Subject: FW: A/76/20/PLLand at Dappers Lane Angmering 84 No. dwellings, public open space, play areas, associated infrastructure & landscaping. This application affects a Right of Way

Subject: A/76/20/PLLand at Dappers Lane Angmering 84 No. dwellings, public open space, play areas, associated infrastructure & landscaping. This application affects a Right of Way

I **object** to this Planning Application.

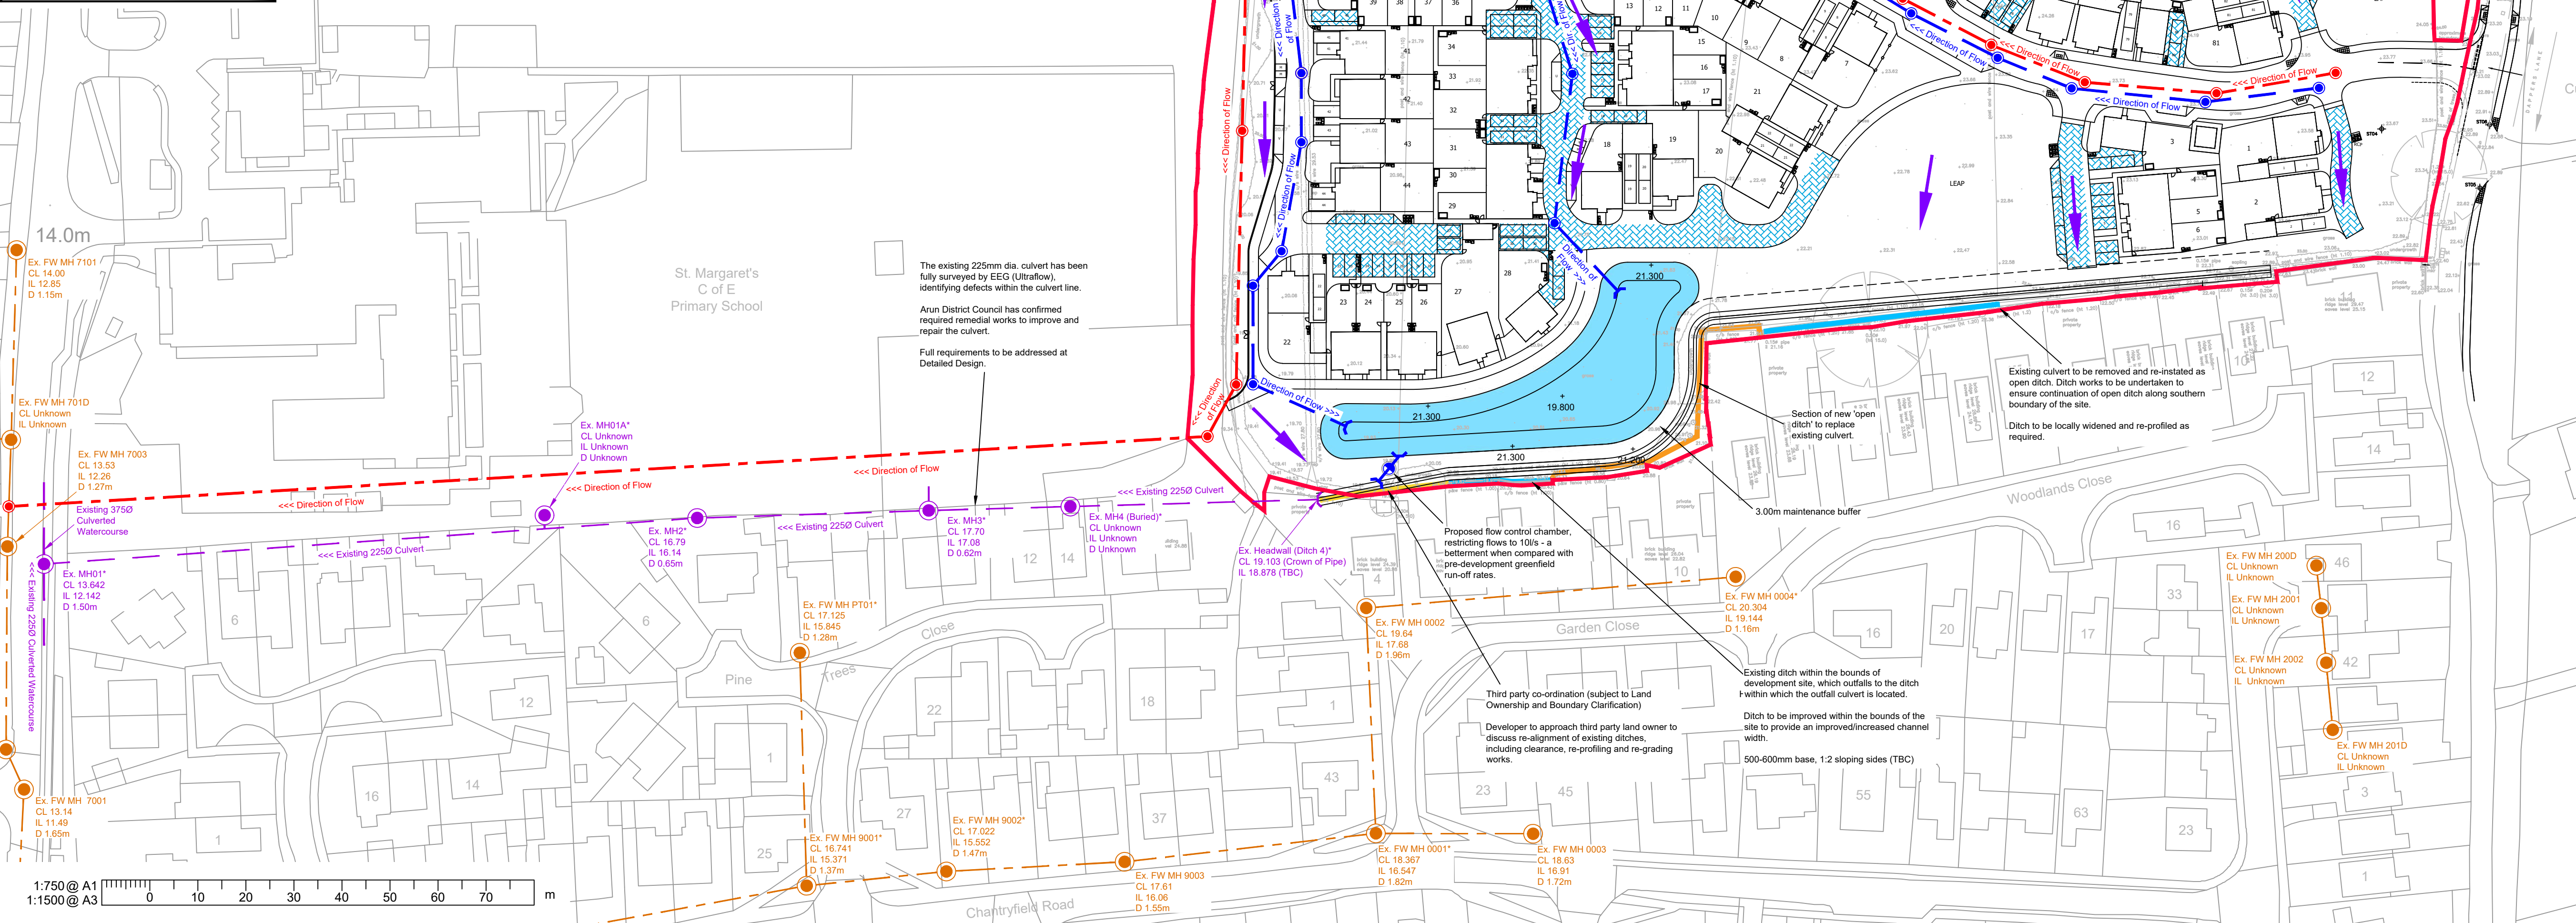
Arun District Council's *'Surface Water Drainage Proposal Checklist'* states at paragraph 12 *'Unless specifically requested by the council's drainage engineers 'Exceedance Flow Route Plans are only required for developments of more than 5 residential properties or more than 0.5 ha of commercial development'*. Eighty-four proposed dwellings are well in excess of the threshold of five properties requiring an *'Exceedance Flow Route Plan'*. No *'Exceedance Flow Route Plan'* has been included with the submitted documents.

My reading of the documents is that the proposal is to discharge the runoff from the site to the watercourse at a controlled rate. It states that attenuation will be both using 'tanked' permeable paving and a lined attenuation pond. Achieving the 'controlled rate' with the site conditions will be challenging and the consequences of not achieving it devastating. This is without considering the conveyance capacity of the drainage system away from the southwest of the site.

The report says the 'tanked' permeable paving will be 450 mm deep and the plan within the FRA shows the attenuation basin as 1.2 metres deep. The shallow depth of groundwater from ground level (zero to 0.35 metres) mentioned above indicates to me that achieving this attenuation will be challenging. Any tanked permeable paving will have to resist groundwater upthrust since, for all of the monitoring wells, at some time, groundwater was recorded above the proposed underside of the 'tanked' permeable paving. Additionally, and even more importantly, the same will be true of the 1.2 metres deep attenuation basin. It is unclear how the developer will ensure that the attenuation pond is empty when needed for attenuation use. The drawings do not show the invert level of this attenuation basin relative to the drainage system away from the site.

The difference the development will create is a positive piped drainage system with elements of 'attenuation' of doubtful efficacy. This suggests to me that the rate of flow arriving at the southwest corner of the site will increase.

NOTES

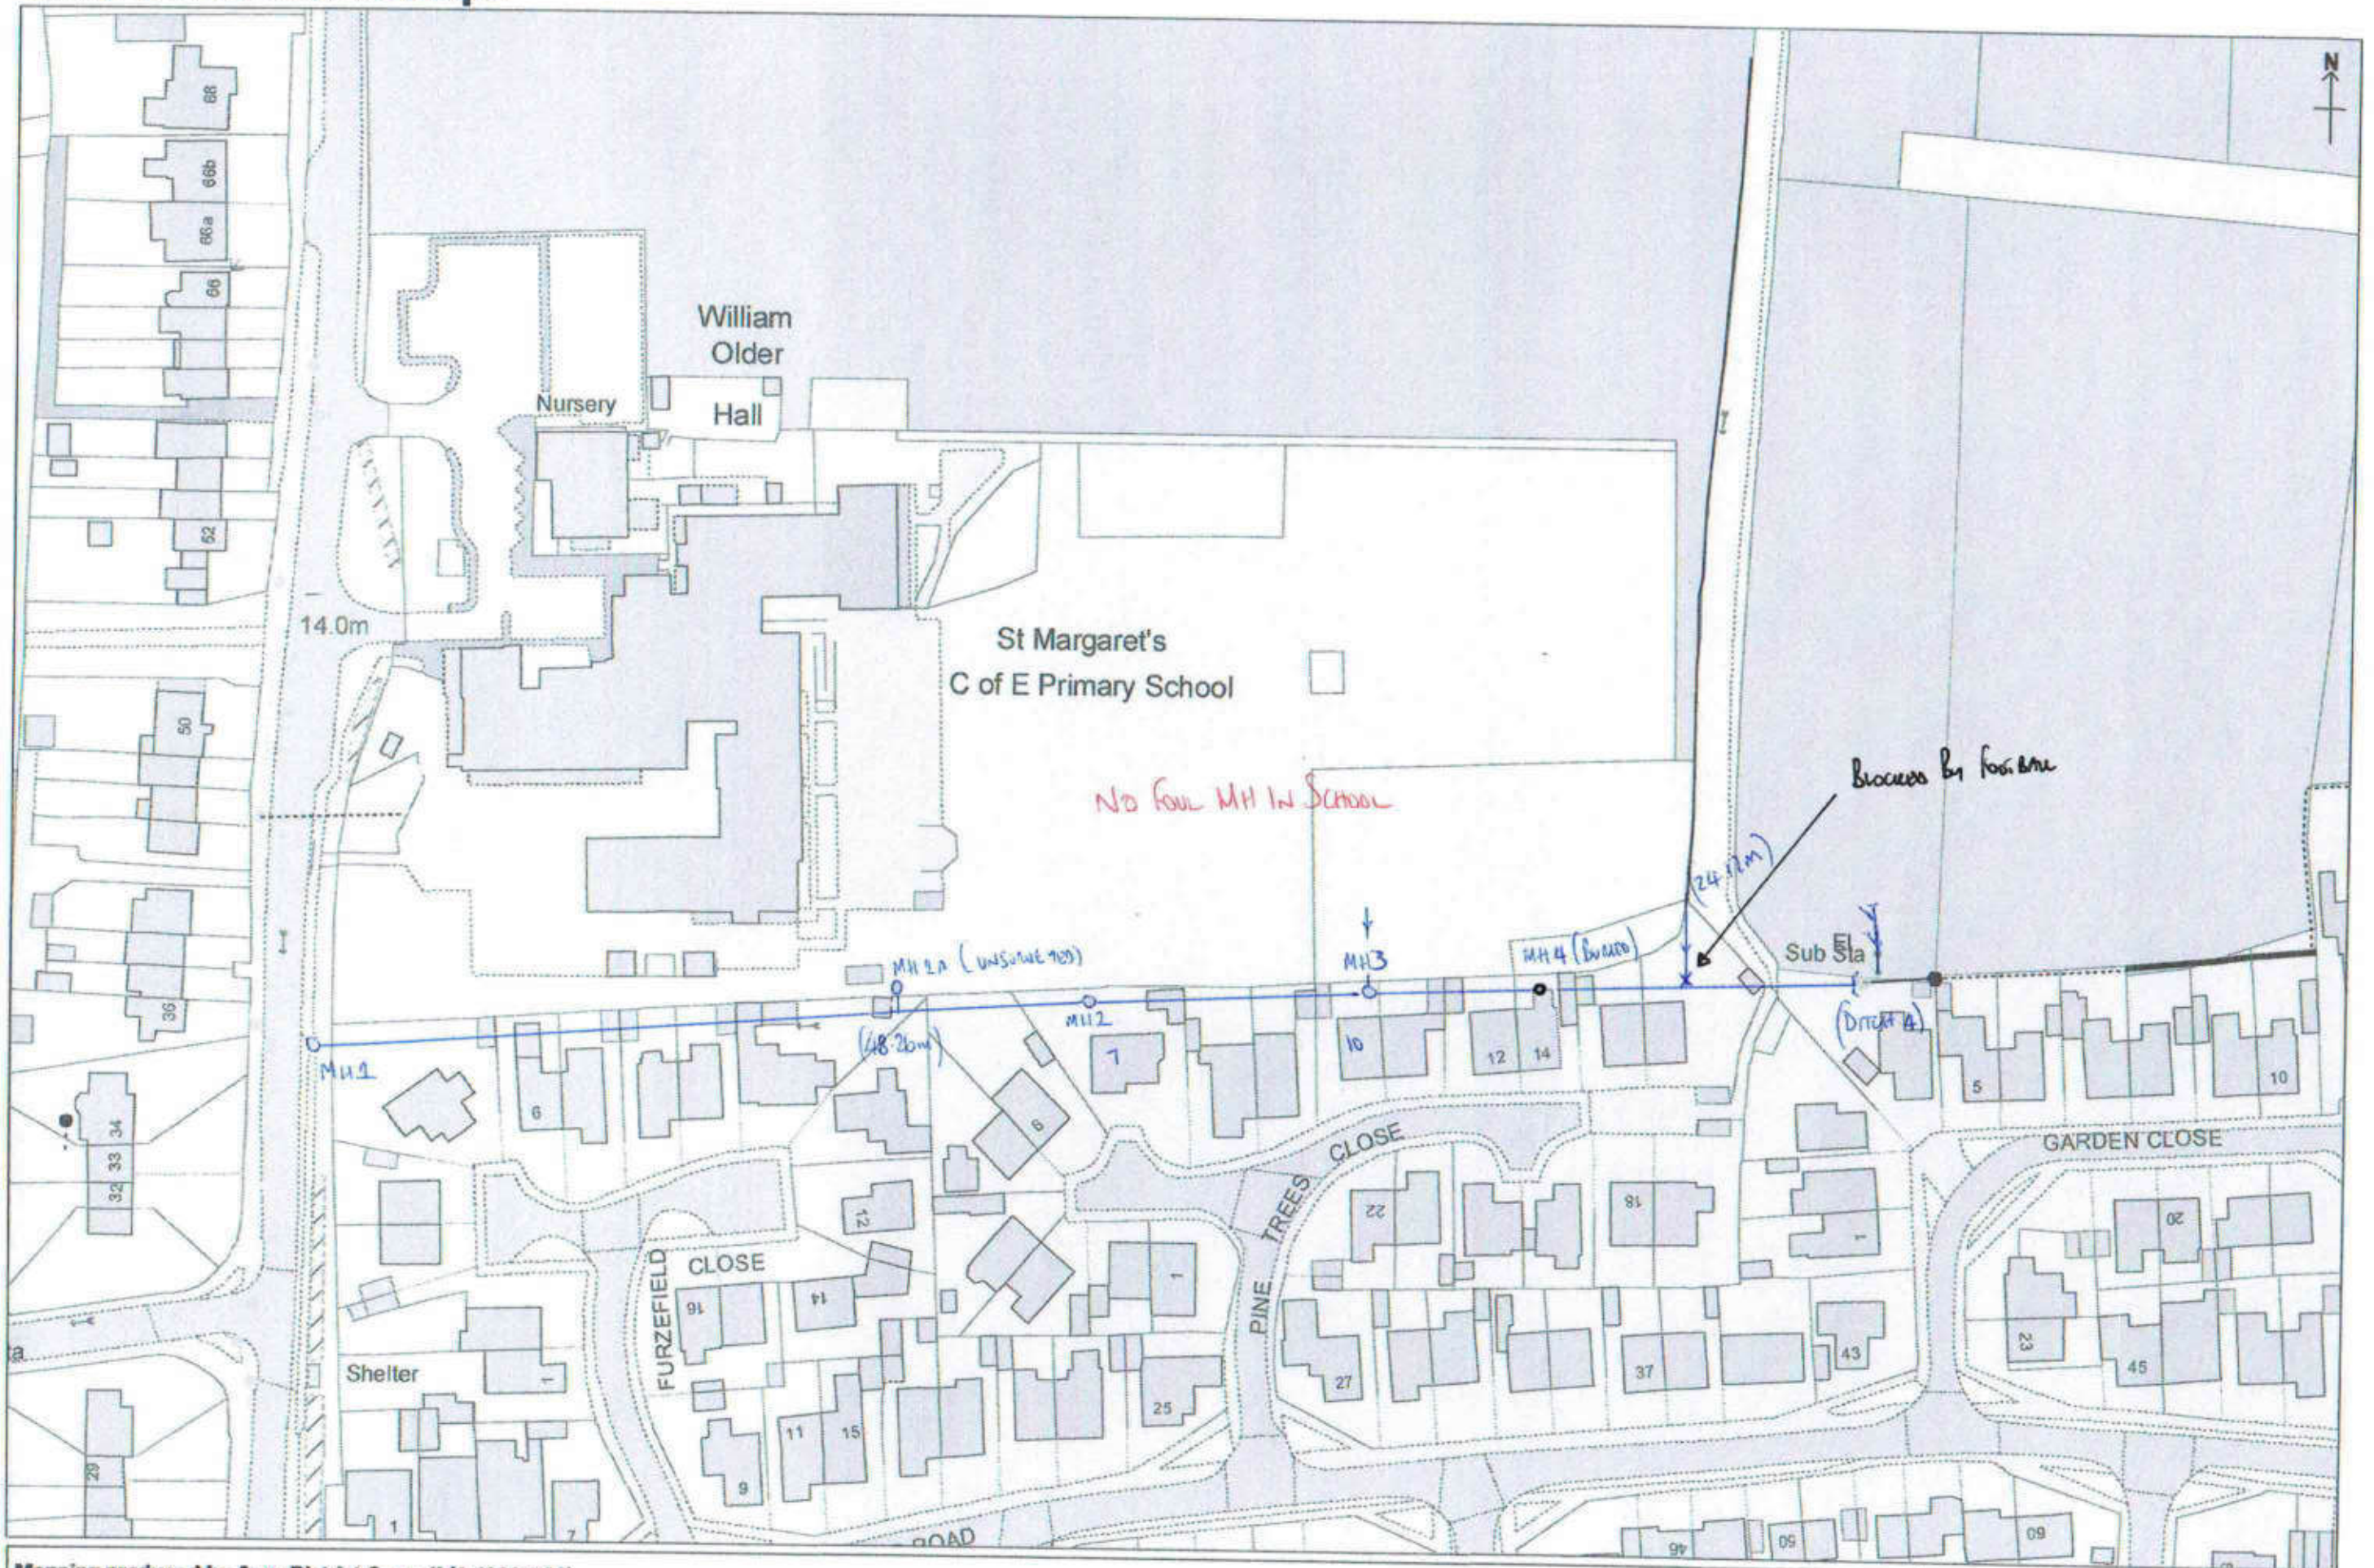
Within the document, 'Appendices drainage details' dated '20/05/2020' there is an Arun District Council Plan showing the line of a pipeline (reported as 225 mm in diameter flowing from the garden of no 4 Garden Close to Arundel Road in a westerly direction through the rear gardens of Pine Trees Close and Furzeffeld Close. There are annotations on this plan.

There is what I assume to be a subsequent e-mail from Arun dated 5 November 2019 that contains comments on structural condition identified by a CCTV survey, which I read along with the Arun District Council Plan referred to earlier. This information puts in doubt the suitability of this pipeline to receive additional flows from this development site.

My understanding is that this pipeline is considered a culverted ordinary watercourse. The status of this pipeline is important. The Arun District Council Plan referred to earlier along with correspondence and survey results suggest this pipe is in doubtful condition and shows structures such as garages erected upon it.
